From: Bloomer, David <David.Bloomer@lancashire.gov.uk>
Sent: 06 July 2017 14:08
To: Robert Major
Cc: LHS Customer Service; planning
Subject: app3/2017/0585 Land at Malt Kiln , Chipping

Dave Bloomer
Highways Development Control
Lancashire County Council

TITLE **HIGHWAY ACCESS ARRANGEMENT**

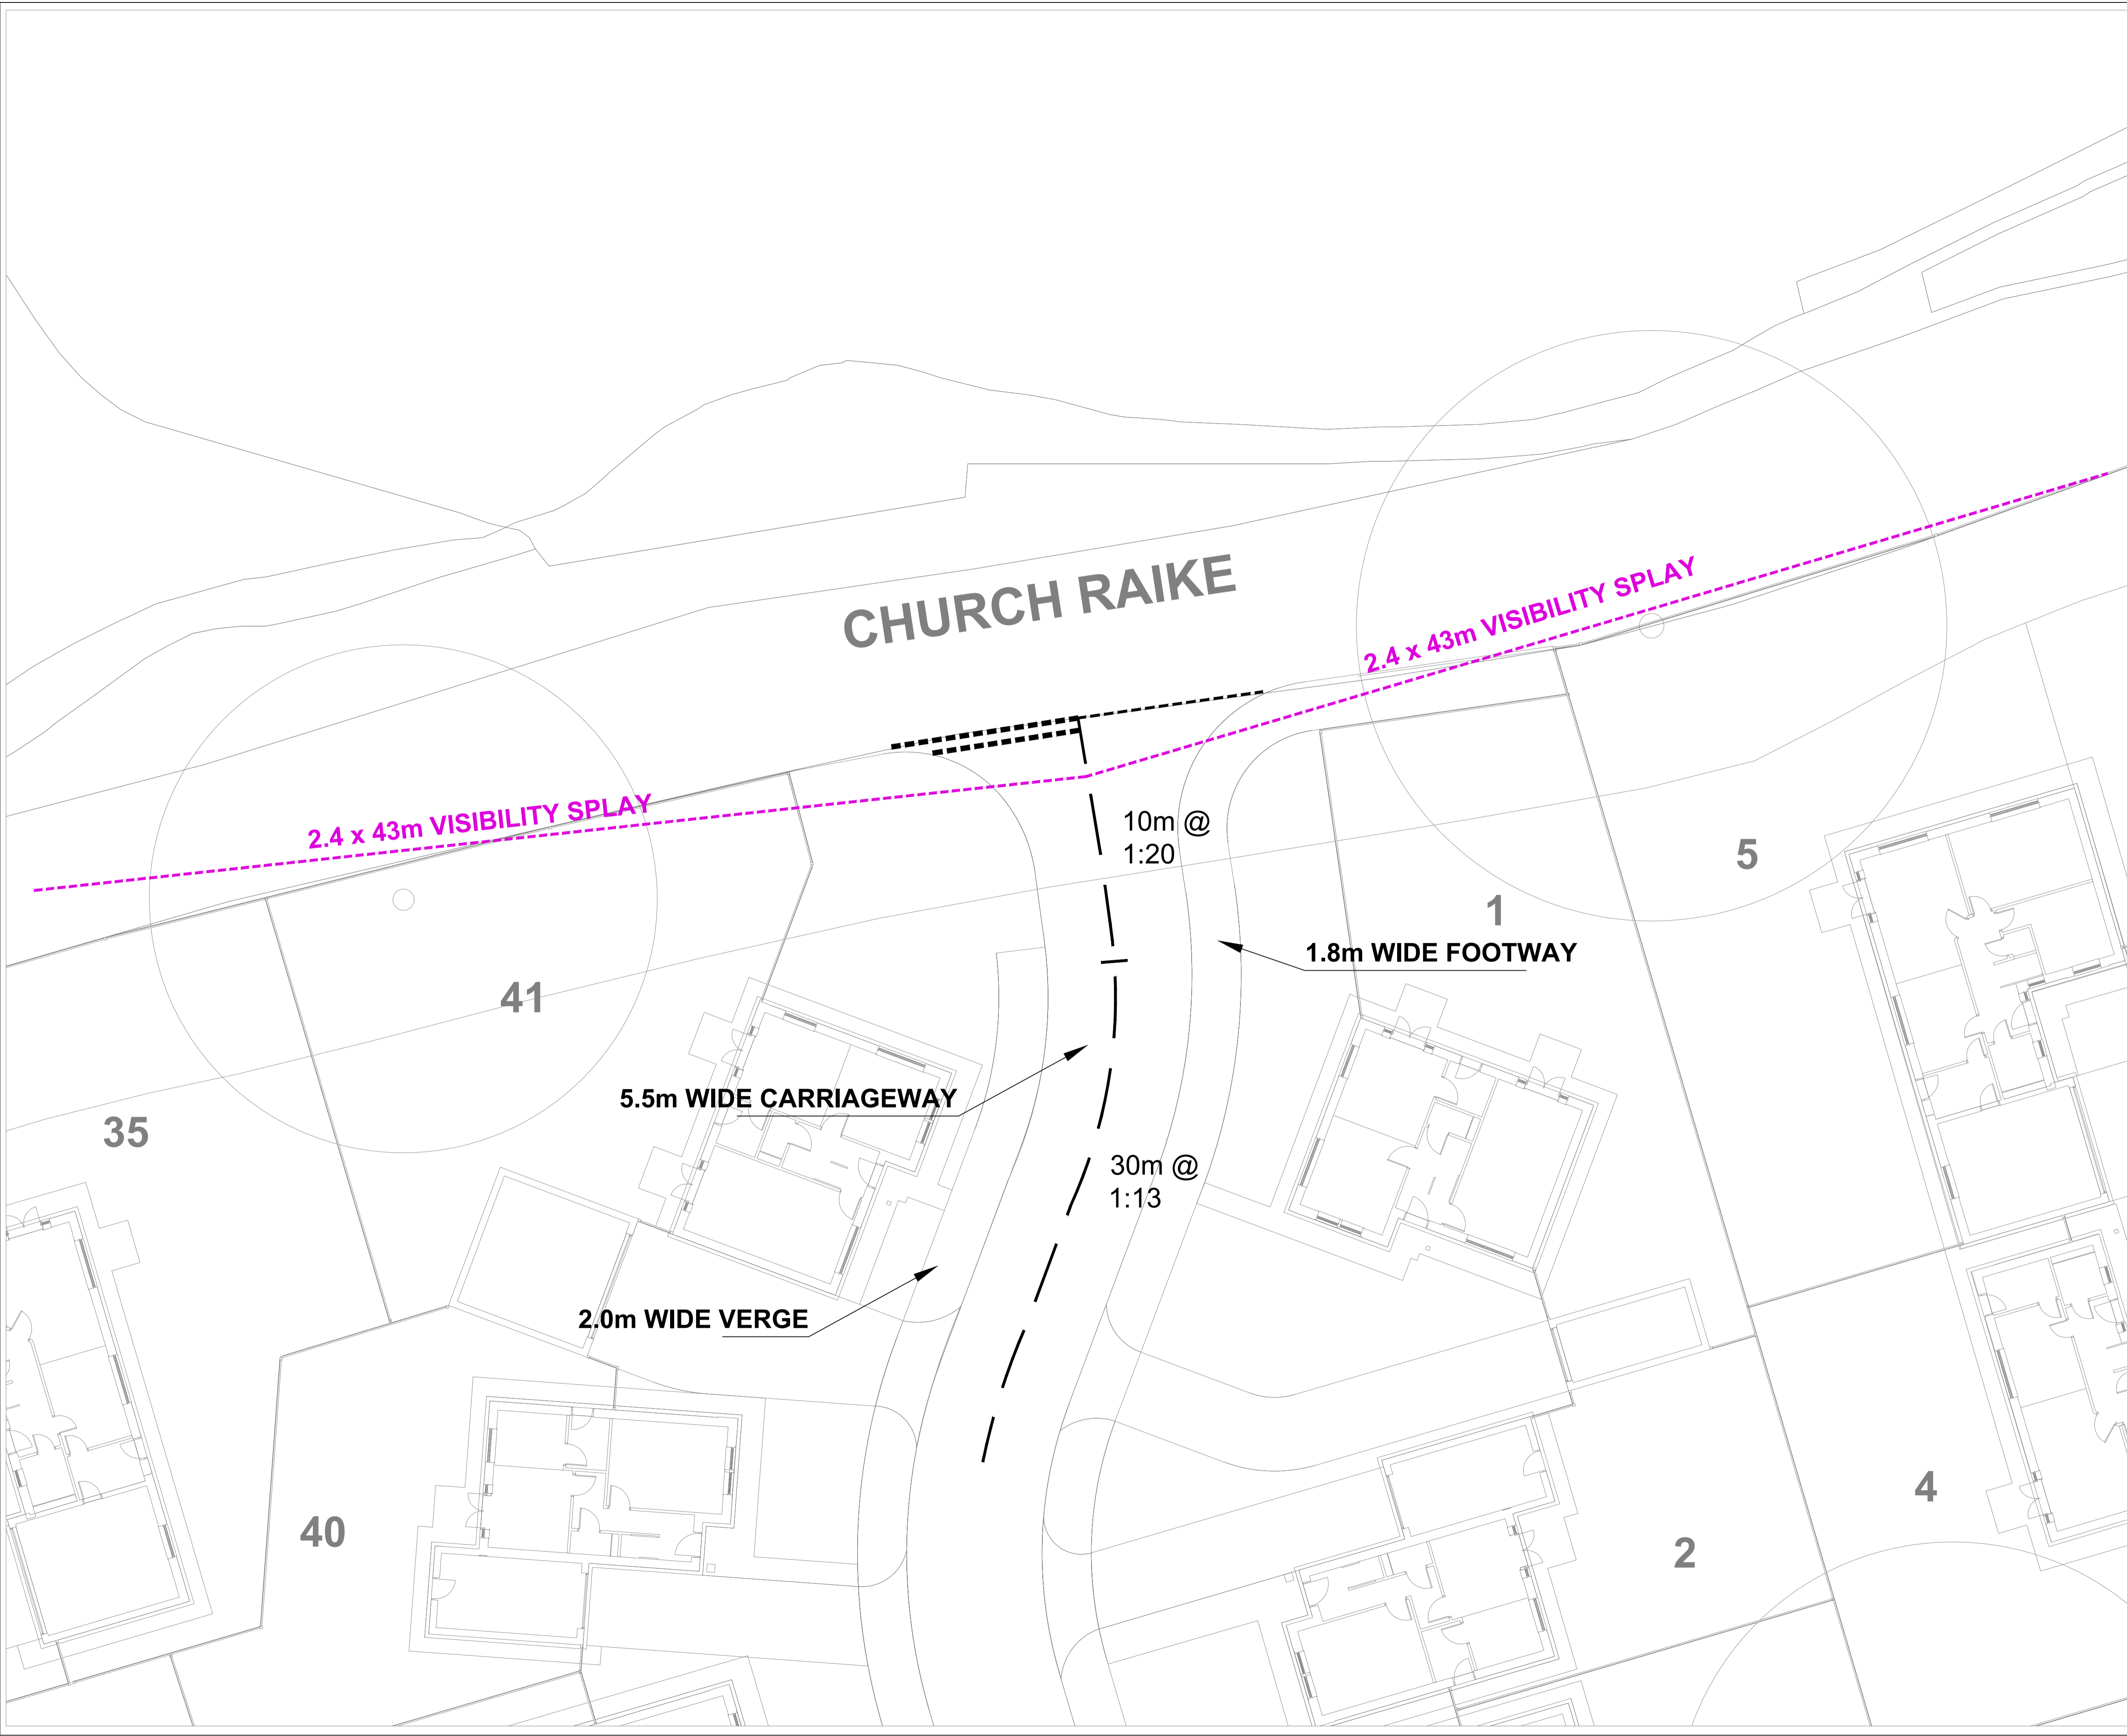
The proposal indicates the available visibility splay as being measured to the centreline to the left on exit. The correct method of measuring would be to the nearside kerb edge. However the revised access location represents an improvement on the visibility over the location which was previously agreed by the Planning Inspector at appeal and on this basis I would raise no objection to the proposal on highway grounds.
